Application: SSI 7485

I write regarding the proposed modification to M4-M5 Link, Mod 2 The Crescent overpass and changes to pedestrian infrastructure in North Annandale, Rozelle and Rozelle Bay Foreshore area.

Figure 4-2 Pedestrian and cyclist bridge infrastructure options

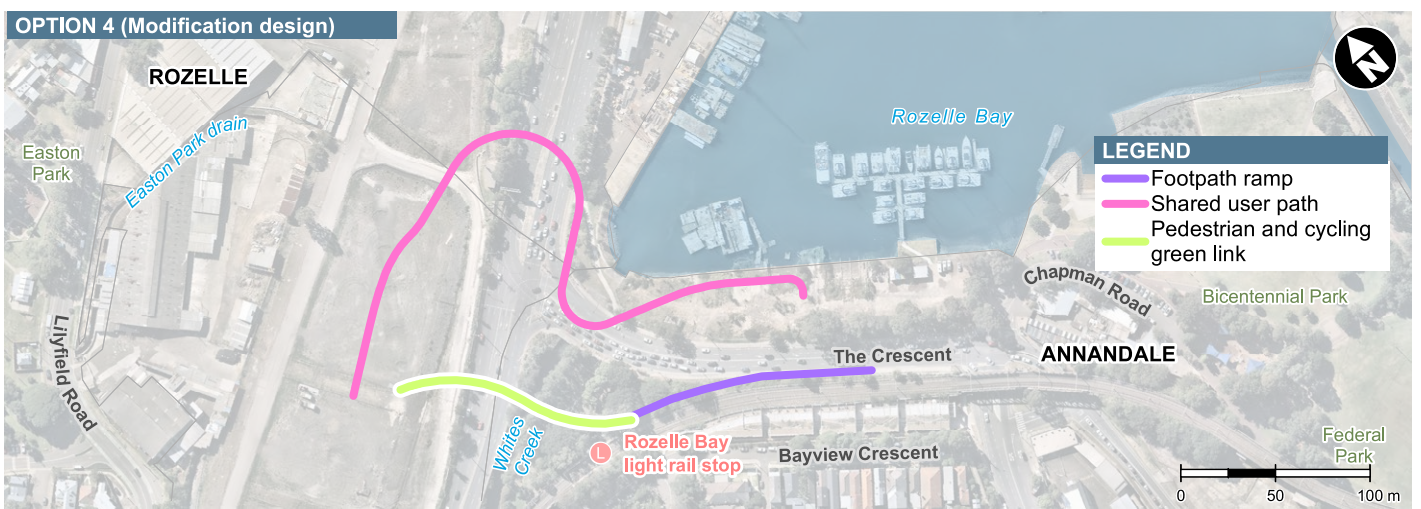
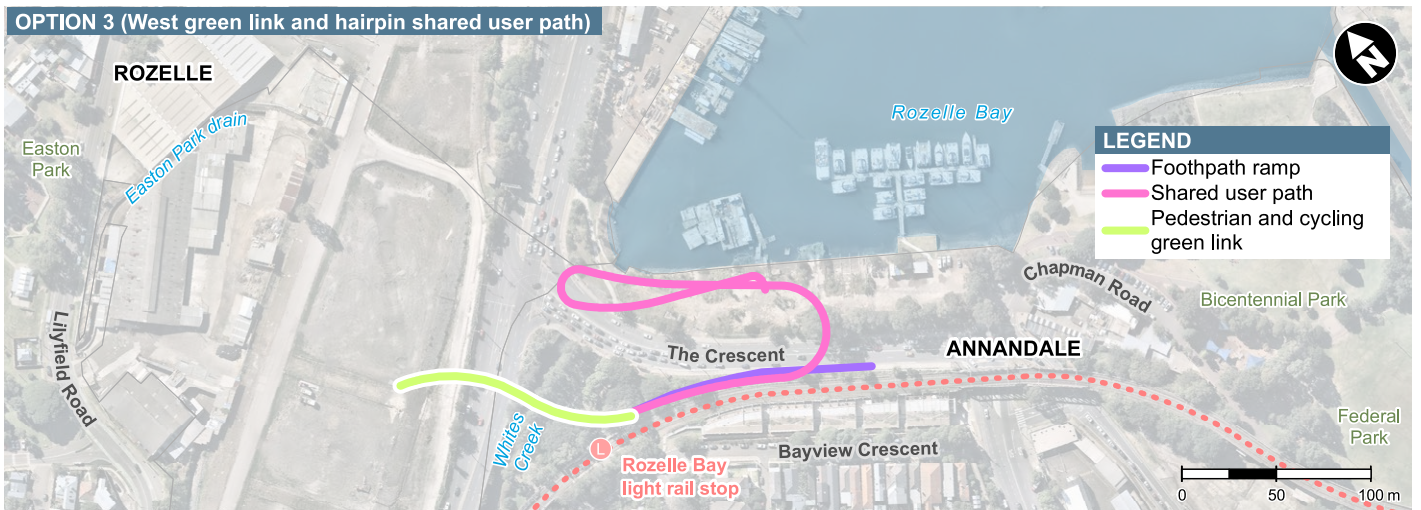
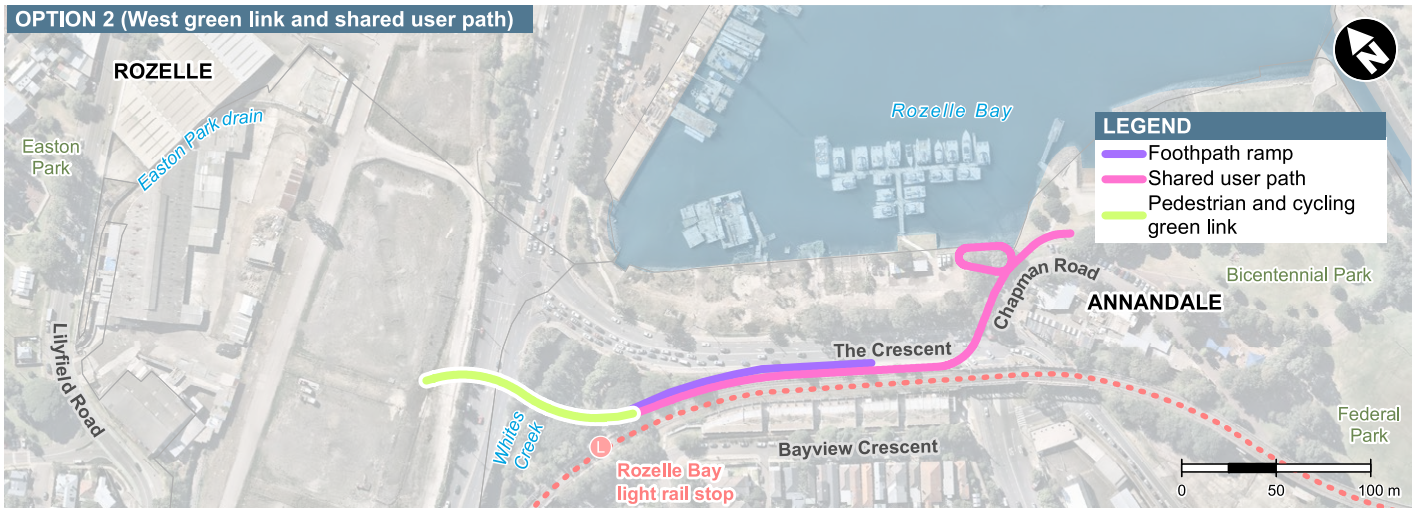
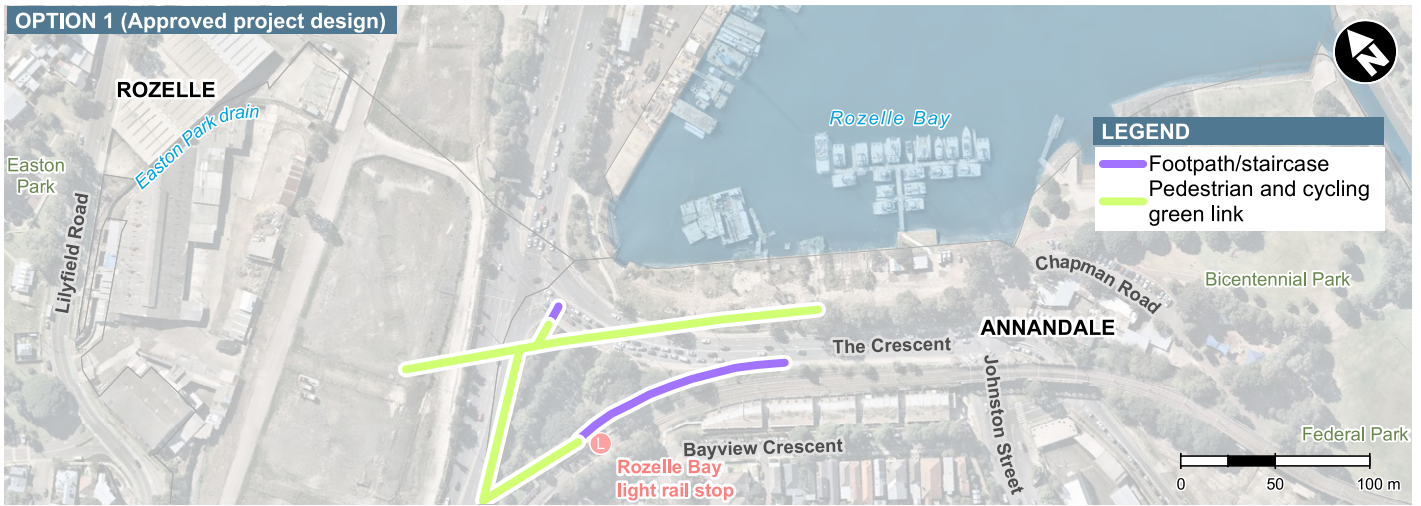
I request RMS work with the community to explore alternate design options to the proposed new car overpass design and the changed pedestrian and cyclist links. I am seeking the reinstatement of the safe, direct access from the approved EIS GreenLink to create a continuous green open space connection from the Rozelle Rail yards and Annandale to the foreshore. The GreenLink was more than just a walk way - it put people central to the design, maximising safety, and providing much needed accessible open space for the community now and into the future Bays Precinct design.

- The significantly reduced safety and increased risk for pedestrians and cyclists with removed access over The Crescent to Bicentennial Park and the increased traffic along Johnson Street.
- Being required to cross five sets of pedestrian lights at The Crescent as my option to reach the foreshore from Annandale or from Rozelle Bay light rail stop.
- Removal of direct active links to the foreshore, cutting the community off from the area and the proposed revitalisation of the entire Bays Precinct, including linking the Light Rail and Bus stops to a Ferry wharf and Metro station.
- Urban and landscape design that is being built before a finalised Masterplan for the area.
- Traffic changes that limit movements around the suburb and create further congestion in the local streets of Annandale, Forest Lodge, Glebe, Lilyfield and Rozelle with no planning to deal with these.

- Reinstate the GreenLink connecting communities and green open space from Rozelle to Bicentennial Park.
- Relocate and design pedestrian and cyclist connections that are continuous, safe and direct.
- Design the modification infrastructure and active links in response to the character of the suburbs, the location of the foreshore and it's potential future development.
- Provide pedestrian and cyclist paths that maximise people's safety and do not force us onto busier streets, unsafe concrete plazas and caged walkways.
- Integrate active and direct connections to all active transport – including the future Metro West and Foreshore Ferry Wharf.
